WAYNFLETE LOWER SCHOOL - ADDENDUM #4 [post bid]

date: Friday, March 31, 2017
project: Waynflete Lower School Addition & Renovations, 2013-0050
prepared by: Austin Smith Scott Simons Architects
to: Cordelia Pitman Wright Ryan Construction
Rick Bergeron Wright Ryan Construction
Luke Dione Wright Ryan Construction
Anne Hagstrom Waynflete School
Patrick Boure Waynflete School
Phil LaClaire PML Project Management

Subject: Addendum #4 to Bid Documents of January 12, 2017

**A131**

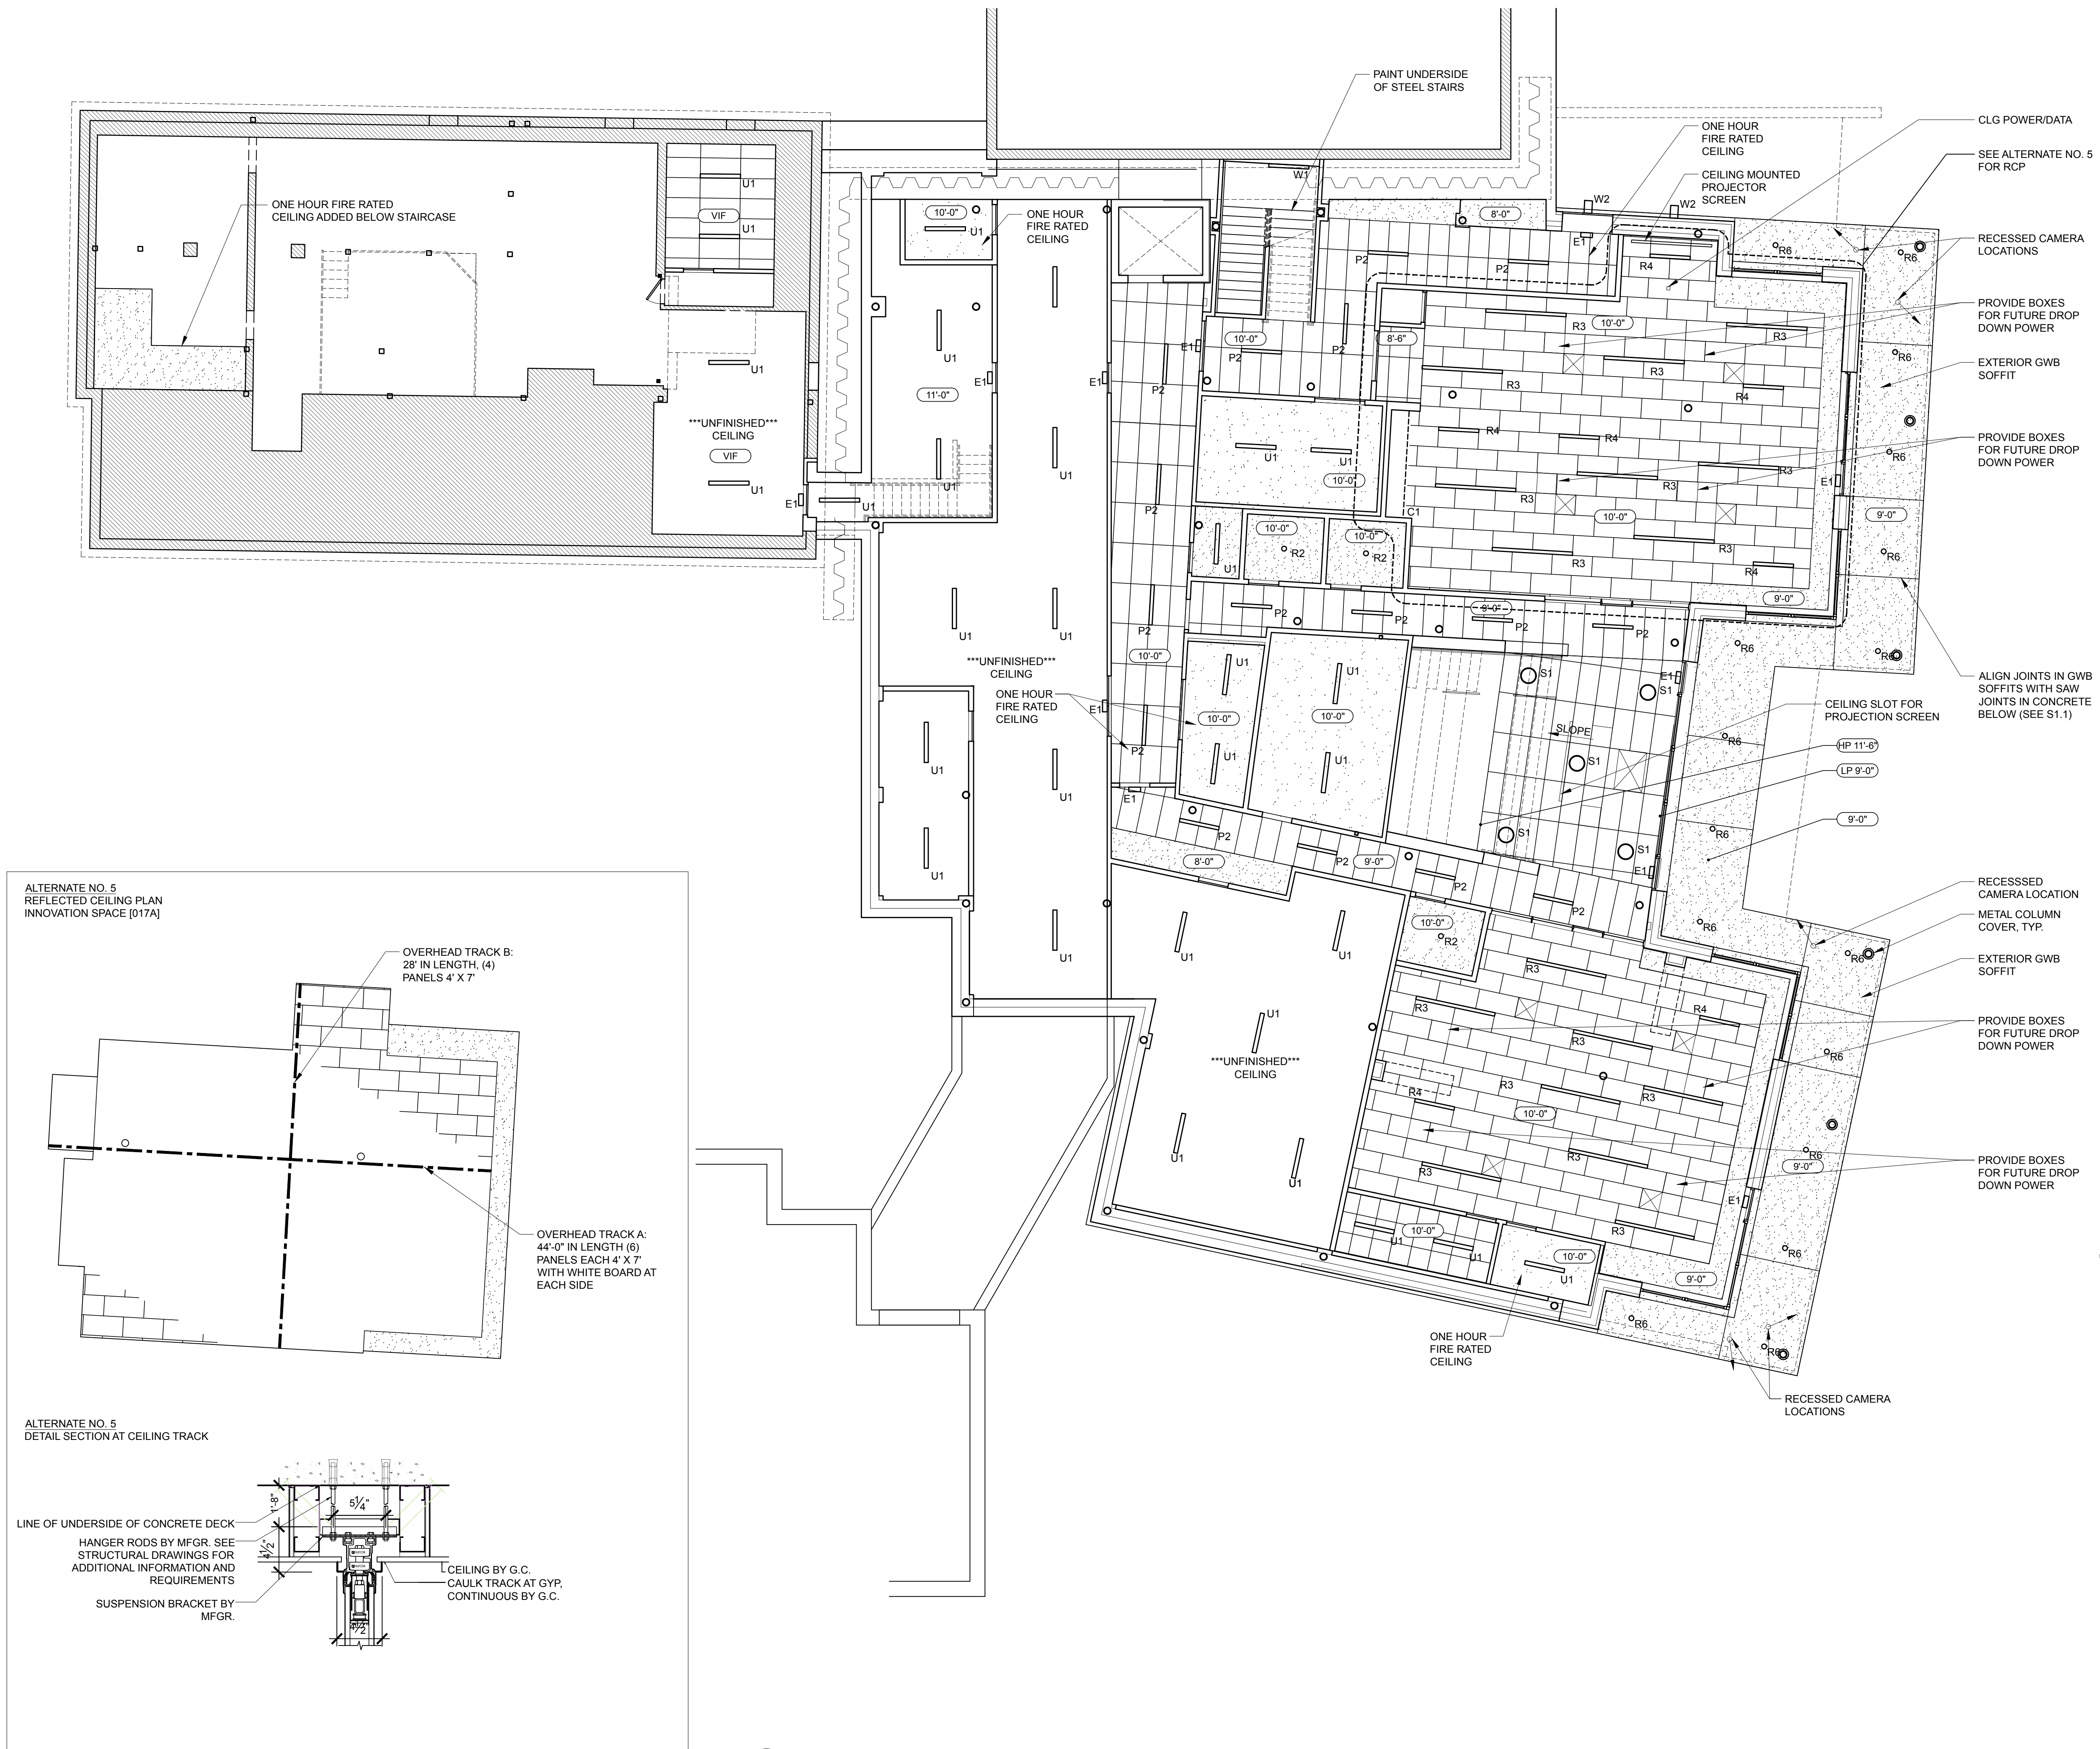
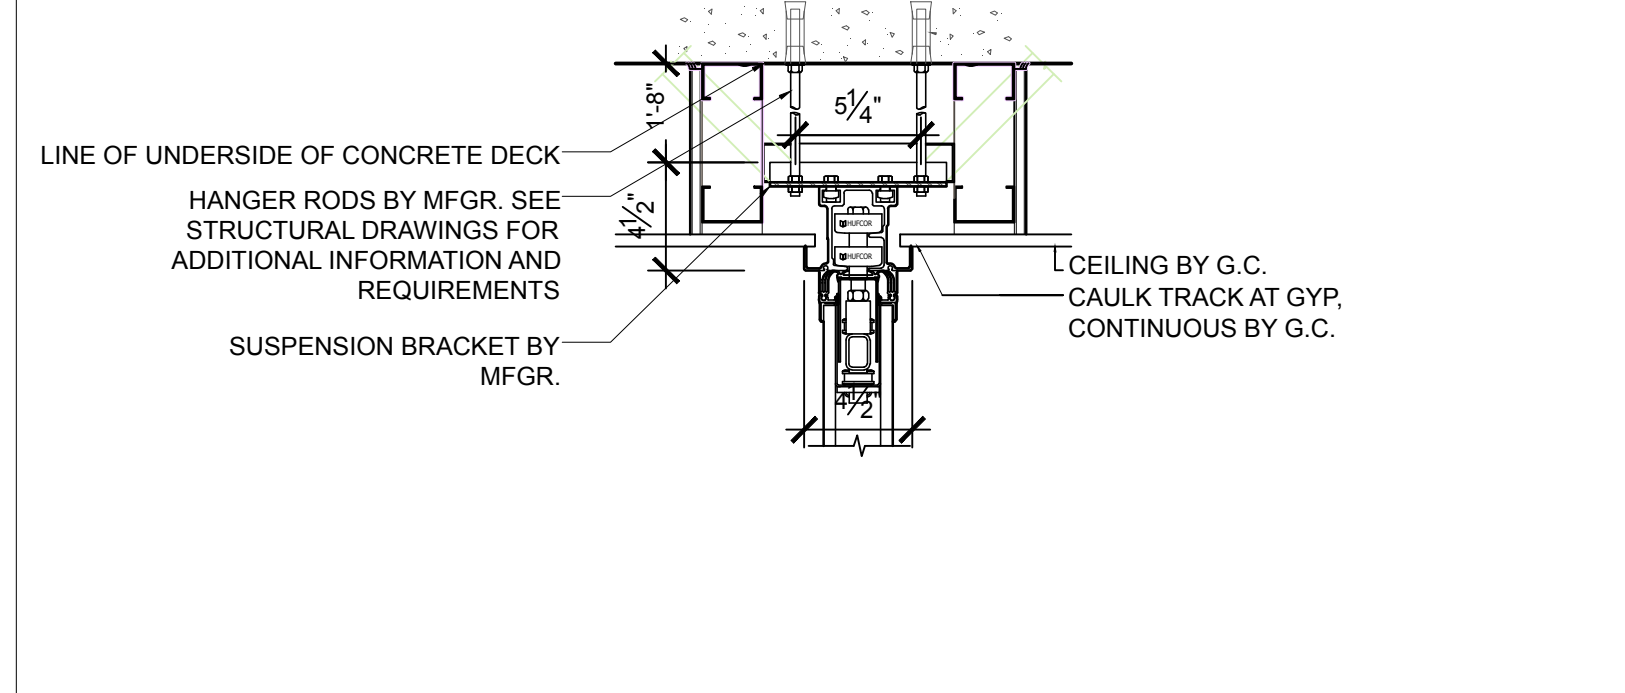
- 4-Q1 Question 1 Q: The 28'0" & 44'0" track lengths given on sheet A131 don't correspond with the room dimensions?
A: On sheet A131, Alternate No. 5 Detail RCP
Revise: "OVERHEAD TRACK
B: 28' IN LENGTH, (4) PANELS 4' X 7' " to say "OVERHEAD TRACK B: 36' IN LENGTH, (4) PANELS 4' X 7'". [Answered via e-mail 2/14/2017]

- 4-Q2 Question 2 Q: Referencing the operable partition Alternate #5 at Innovation Space 017A: The panels are noted at 4'x7'. Is the panel and track height 7'0"? The ceiling height in the area is 10'0"?
A: The panel height is to be at 8'-0. The track is to be recessed in the ceiling per the detail shown on A131. [Answered via e-mail 2/14/2017]

- 4-D1 Sheet A131 At "Exterior GWB Soffit" Note:
Add: ": Provide level 5 finish skim-coat over sheathing, typical. Provide V-groove vinyl trim at control joints"
- 4-D2 Sheets A523,
A525
A536
A528 At classroom interior elevations all instances of this note:
Delete: "Dry erase paint surface, final extents to be coordinated w/ architects"
- 4-D3 Sheet A601 Under General Notes related to the Door and Frame Schedule:
Add: "5. All paired doors with combination 3'/2' doors, the 2' leaf shall be inactive with use of egress hardware"

**UPPER LEVEL  
FINISH FLOOR PLAN**

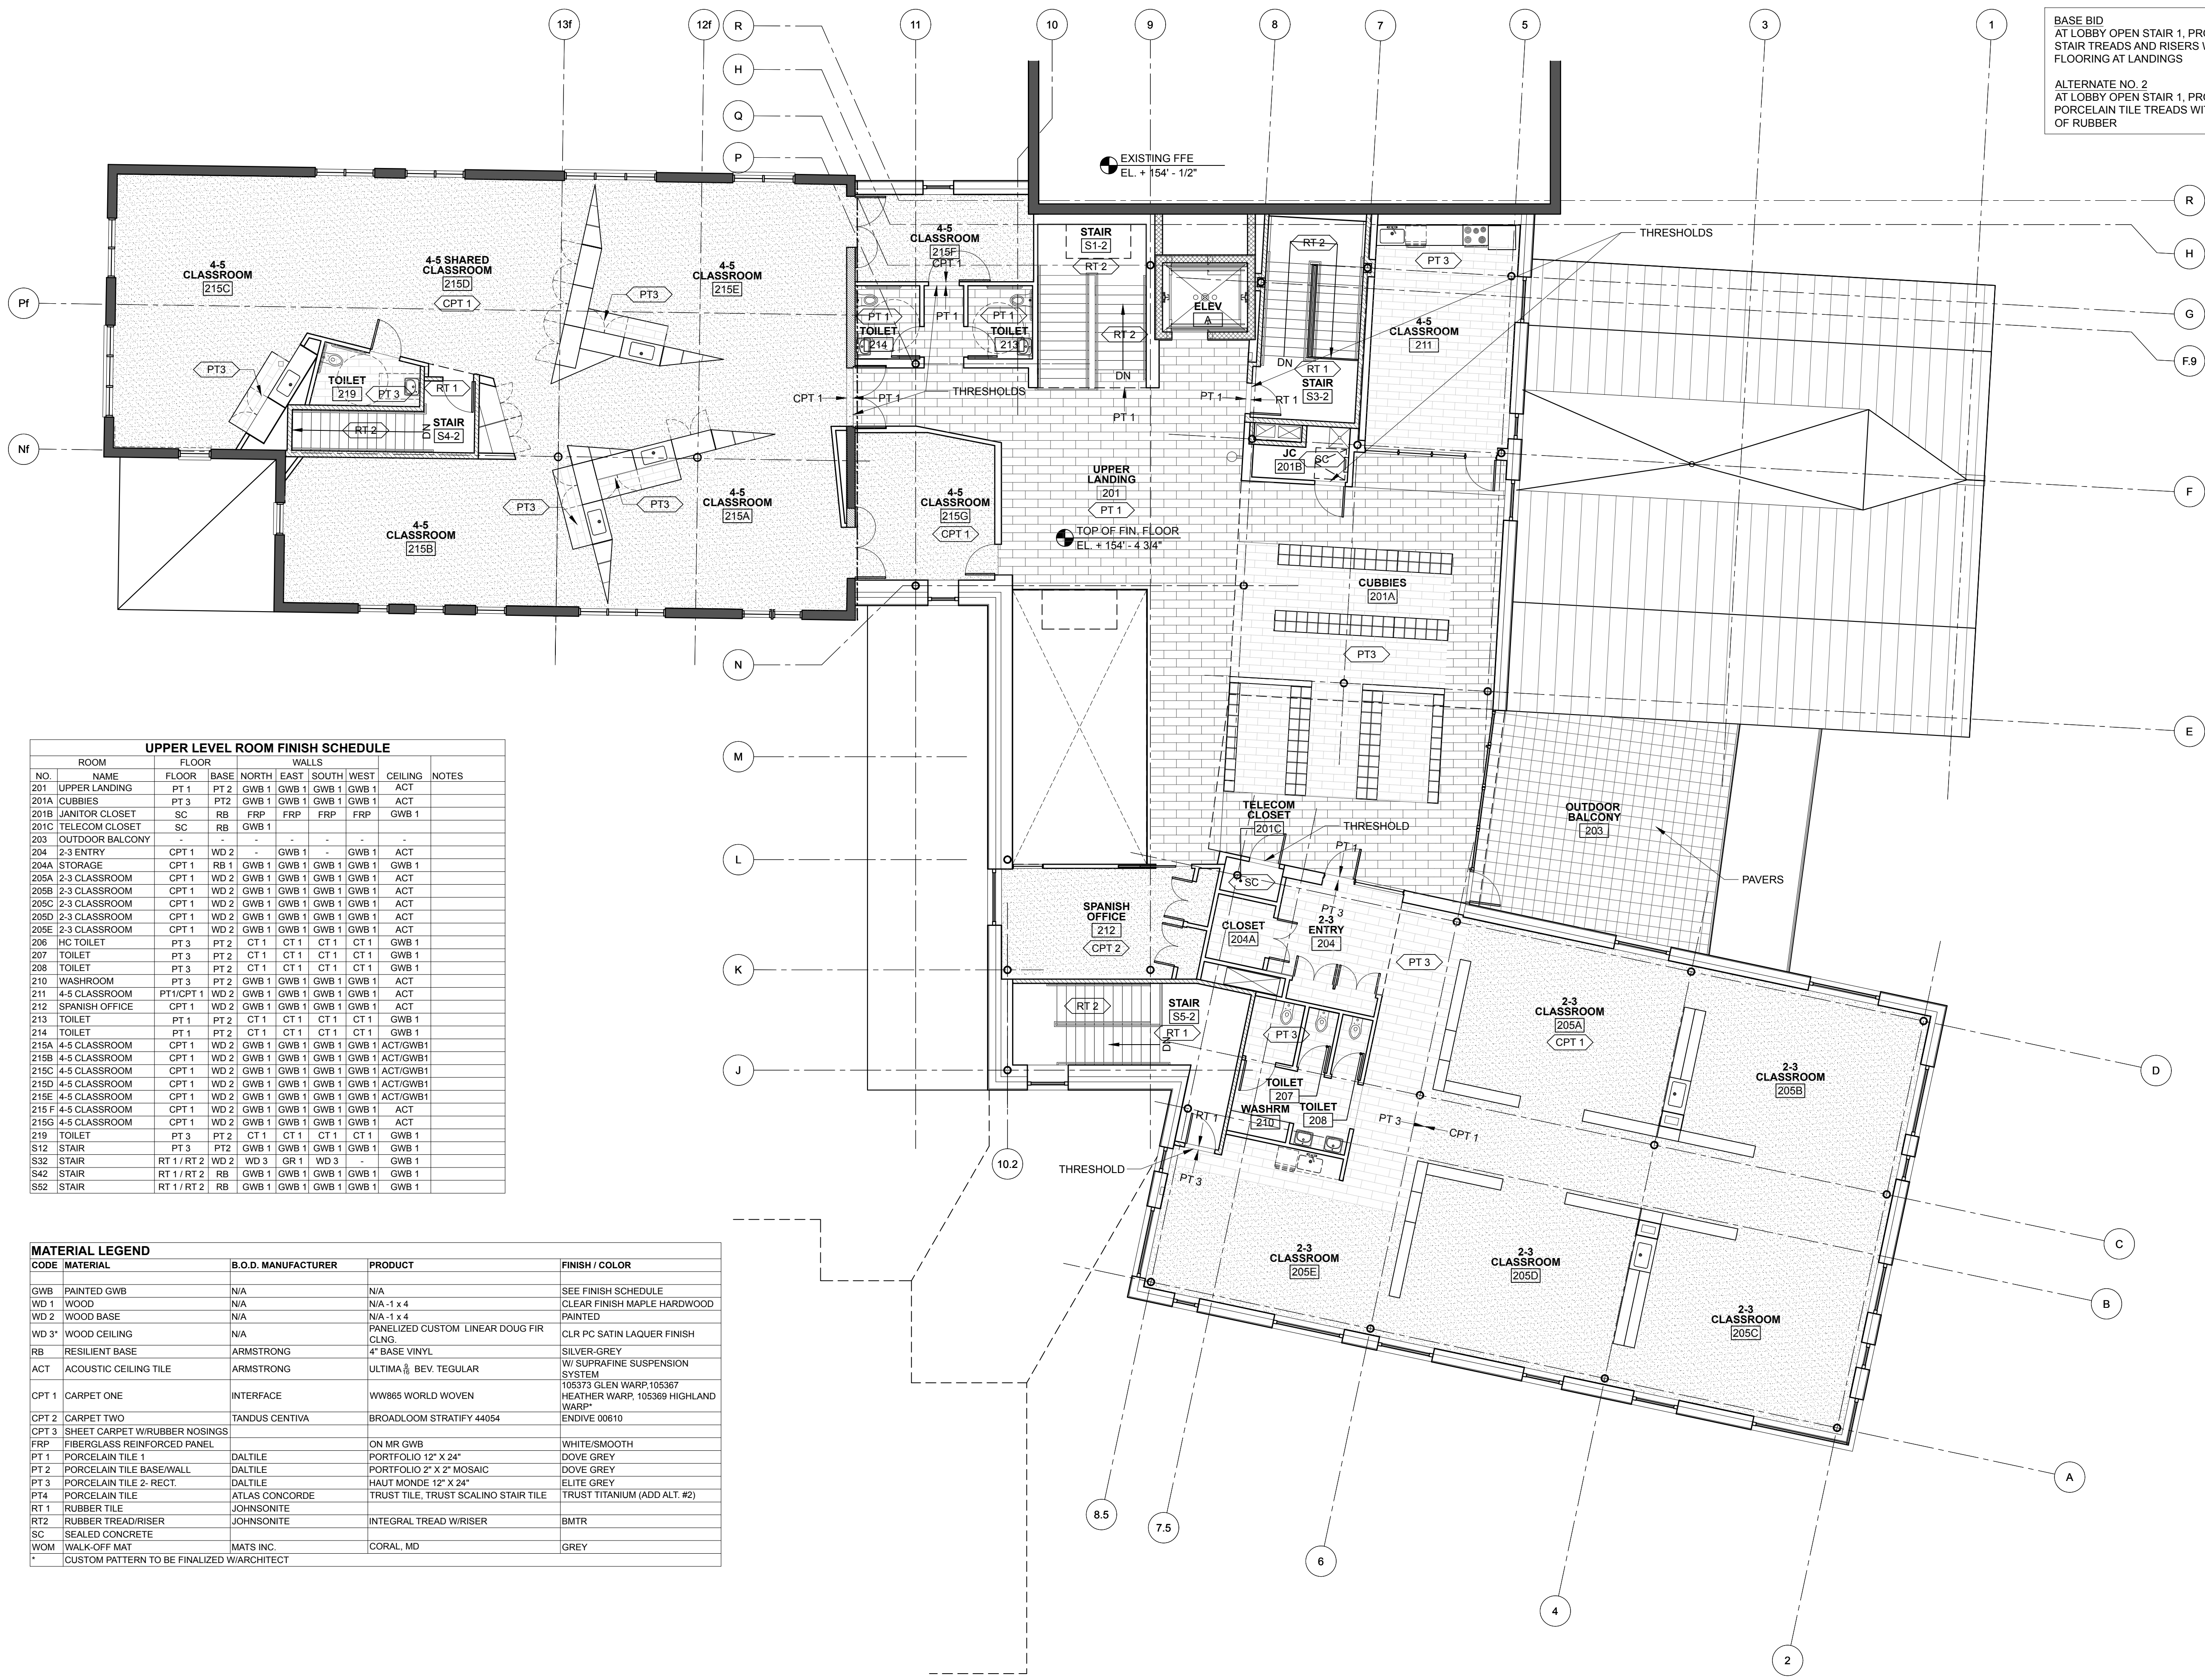
4-Q5	Question 5	Q: Referencing the operable partition Alternate #5 at Innovation Space 017A: If tackable vinyl, is a gypsum backer acceptable for tackable or do they want 1/8" or 1/4" cork backer on the gyp to serve as tackable? A: Please see above. <i>[Answered via e-mail 2/14/2017]</i>
4-Q6	Question 6	Q: Please confirm whether Floor Tile PT-2 2"x2" Mosiac Sheet is to be used as the cove base? A: Please see SKA-08, Revised Finish Schedule attached.
4-Q7	Question 7	Q: Please clarify 212 Spanish Office - CPT-1 on Schedule or CPT-2 as shown on the Plan? A: 212 Spanish Office is to be CPT-1 per schedule.
4-Q8	Question 8	Q: Please clarify 211 – Classroom – PT-1/CPT-1 on Schedule or PT-3 on Plan? A: 211 Classroom is to be PT-3. CPT-1 to be area overlay, location to be determined with client as FF+E selection is determined, 150 SF assumed.
4-Q9	Question 9	Q: Please clarify 204, 204a – CPT-1 on Schedule or PT-3 on Plan? A: Please see SKA-08, Revised Finish Schedule attached.

4-Q10	Question 10	Q: Please clarify S12 Stair – PT-3 on Schedule or RT-2 on plan? A: Please see SKA-08, Revised Finish Schedule attached.
4-Q11	Question 11	Q: Please clarify the rigid insulation on the foundation walls. Wall Assembly #3 indicates 6" of rigid. Wall section 2/A311 indicates thicker insulation at the upper portion of the wall and less insulation down low on the wall. Which foundation walls have 6" of rigid and which have 3"? What is the insulation thickness between the excavation support system and the concrete foundation wall?

- 4-SK-01 SKA-08R Revised Finish Schedule [A142R, A143R] [Issued 2/16/2017],
[Revised 3/31/2017 per accepted post-bid VE Items 2,3,4,5]
- 4-SK-02 SKA-09 Motorized Shade Clarification [Issued 2/22/2017]
